Recommendation Report for Planning Permission**REF NO:** AB/120/12/**LOCATION:** Land adjacent to
84 Maltravers Street
Arundel**PROPOSAL:** Erection of 1 No new dwelling (resubmission following AB/8/12/)**SITE AND SURROUNDINGS**

SouthWest Elevation

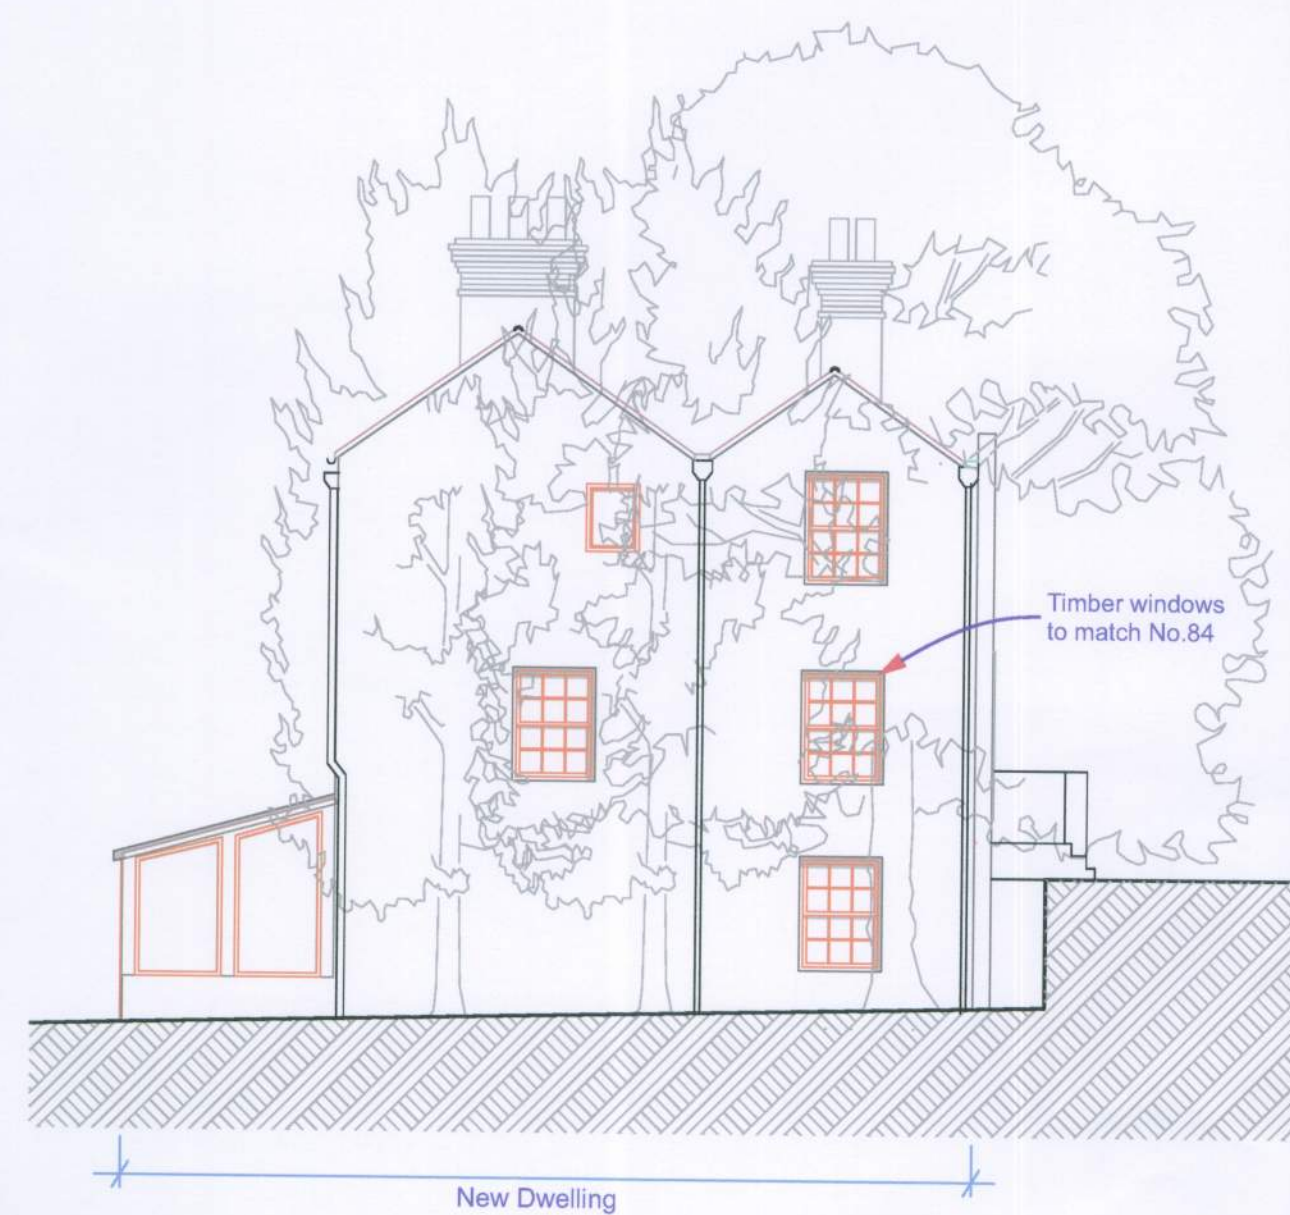
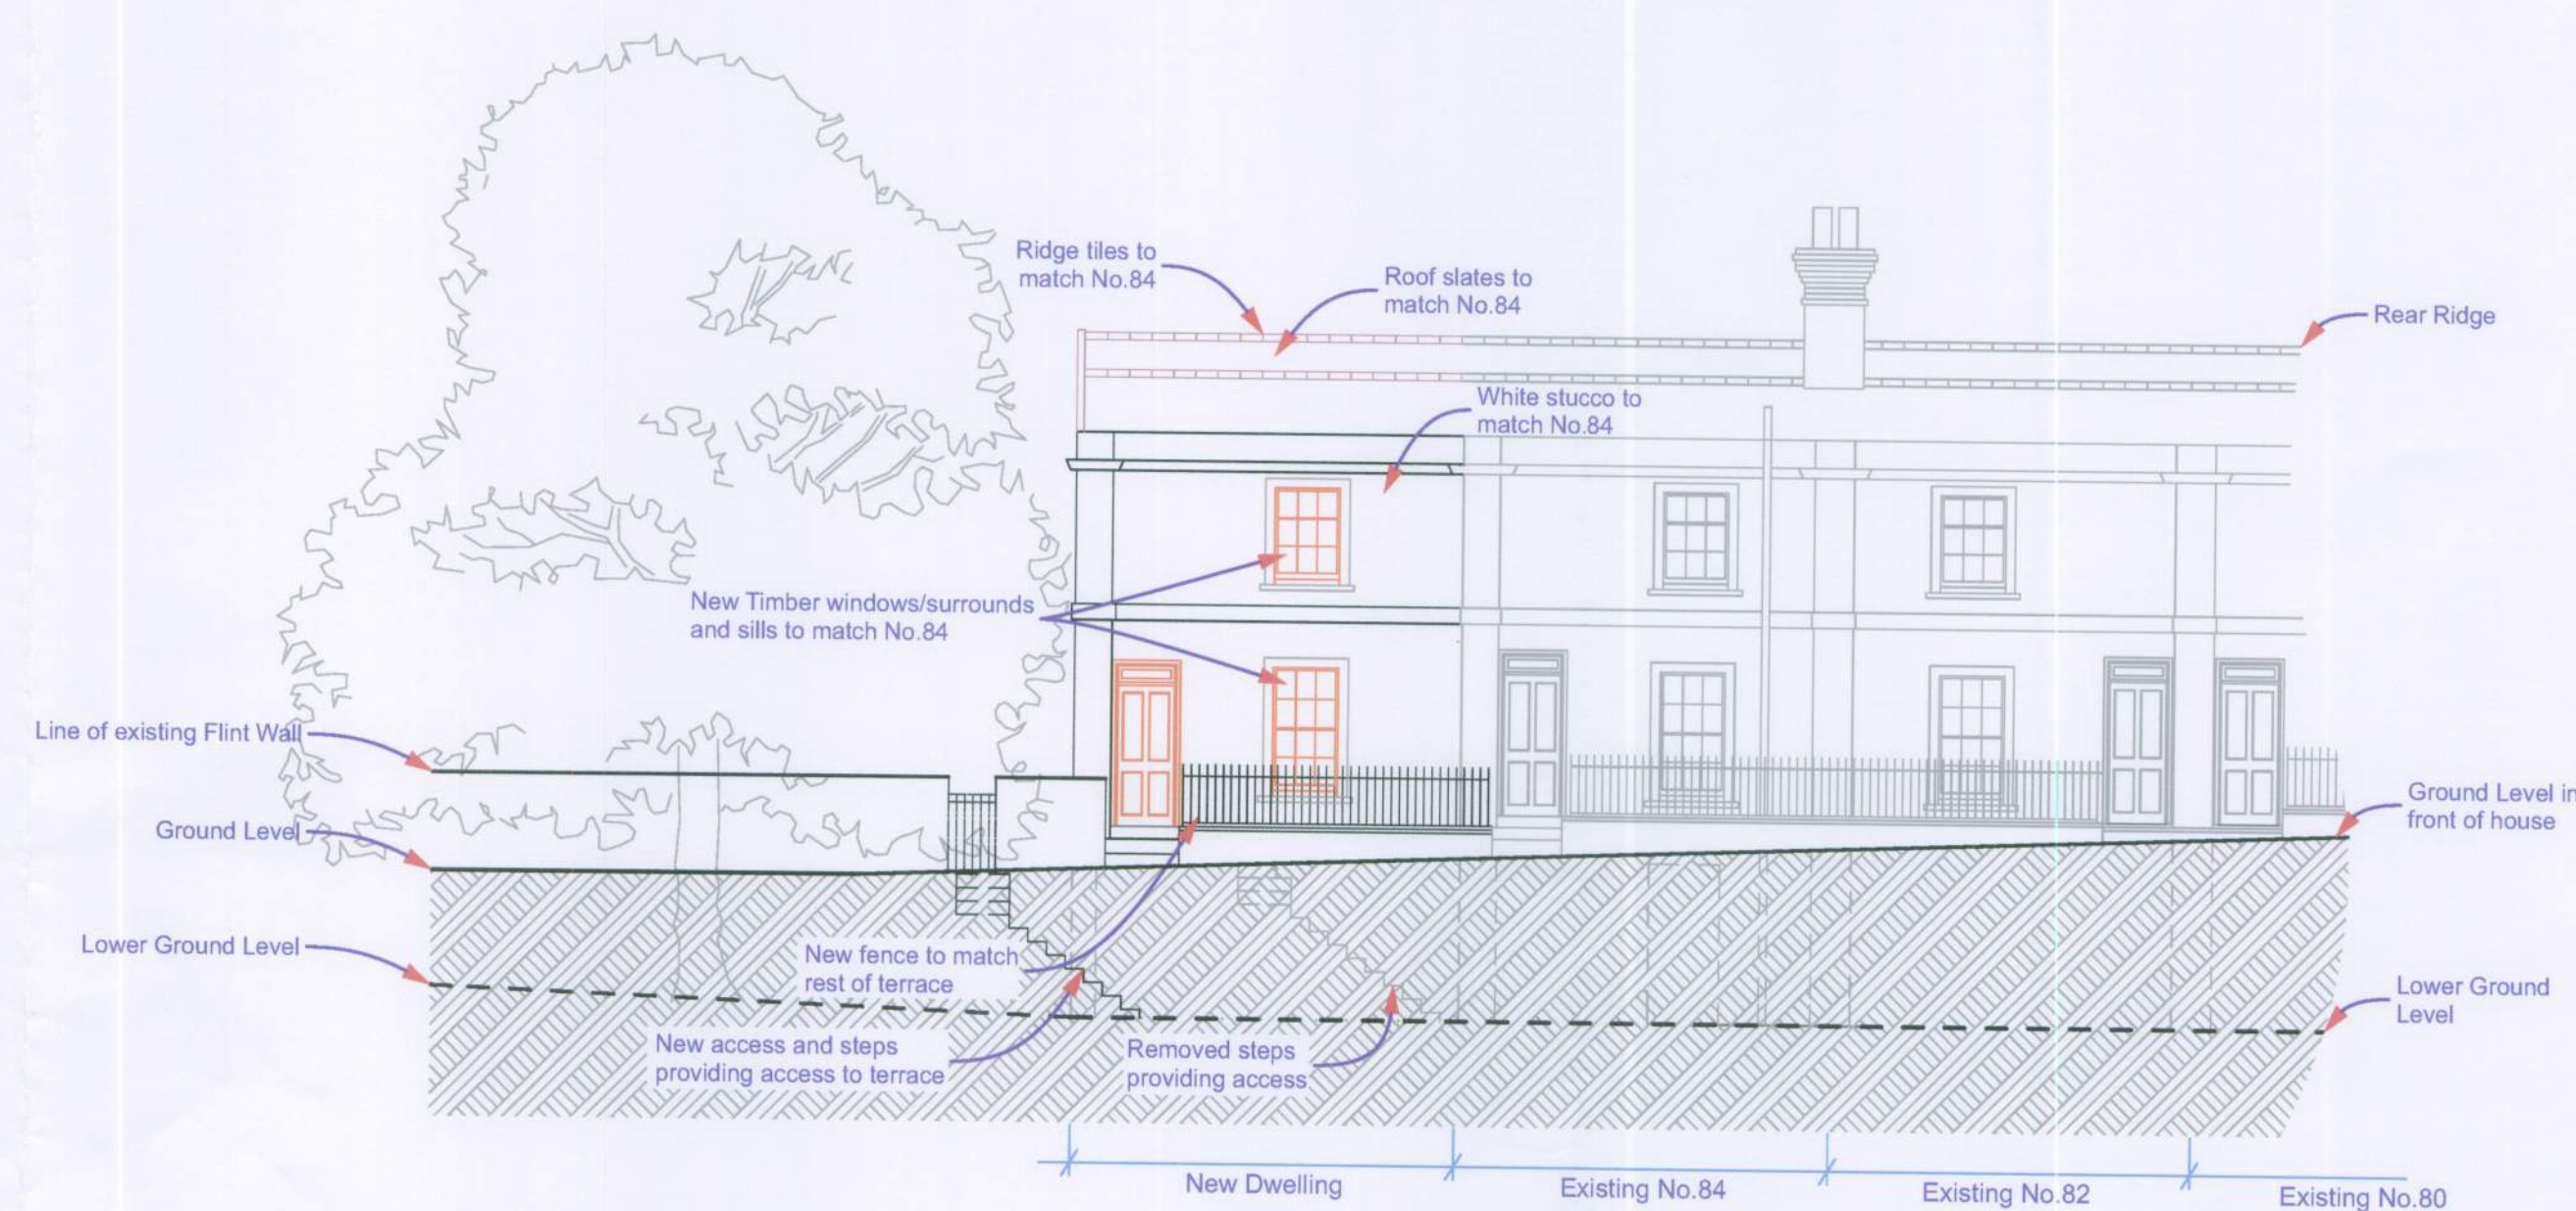
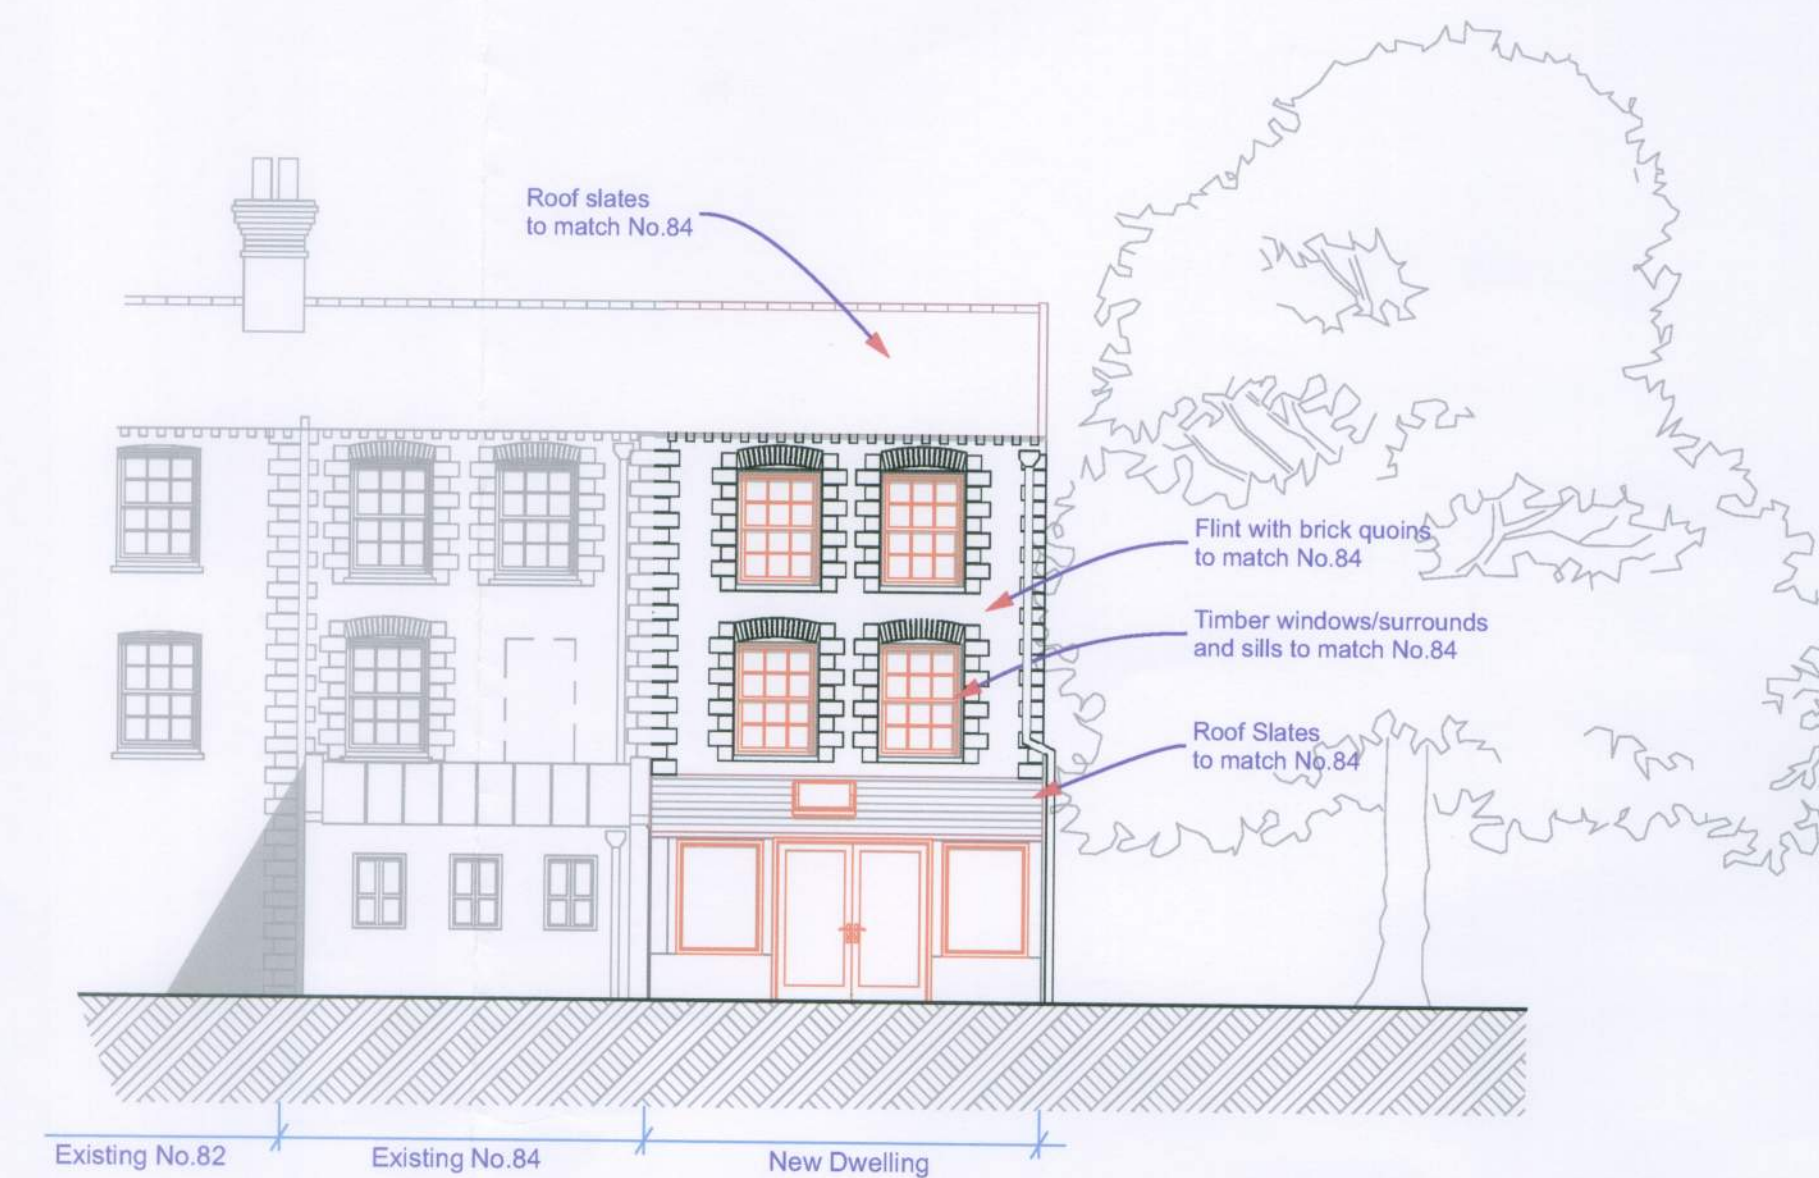
However, the adjacent building is listed and is located within a Conservation Area. The terrace has a strong cohesion in terms of its symmetry and is a significant and distinctive feature of the Conservation Area as entered from the main highway. Beyond the site boundaries historic buildings on Park Place and Mount Pleasant can be viewed. These longer views contribute positively to the character and appearance of the Conservation Area. The addition of a dwelling in this location therefore compromises the historic form and design of the terrace and the space around it and its broader contribution to the Conservation Area. The proposal is therefore contrary to advice contained in the National Planning Policy Framework and conflicts with Policy AREA 2 of the Local Plan.

The application is a resubmission of an earlier refused application (AB/8/12). The design amendments which include changes to the appearance of the dwelling so that it is now the same height as the existing and is not set in from the site frontage have not overcome the previous reasons for refusal.

- 1 The site is adjacent to a Listed Building within an area designated as a Conservation Area under Section 69, 70 and 72 of the Planning (Listed Buildings and Conservation Areas) Act 1990 and the proposal by reason of its siting and size would conflict with the Local Planning Authority's intention to protect and enhance the visual amenities and environment of such areas and would be detrimental to the setting of the listed building, and with policies GEN7 and AREA2 of the Arun District Local Plan and the National Planning Policy Framework.
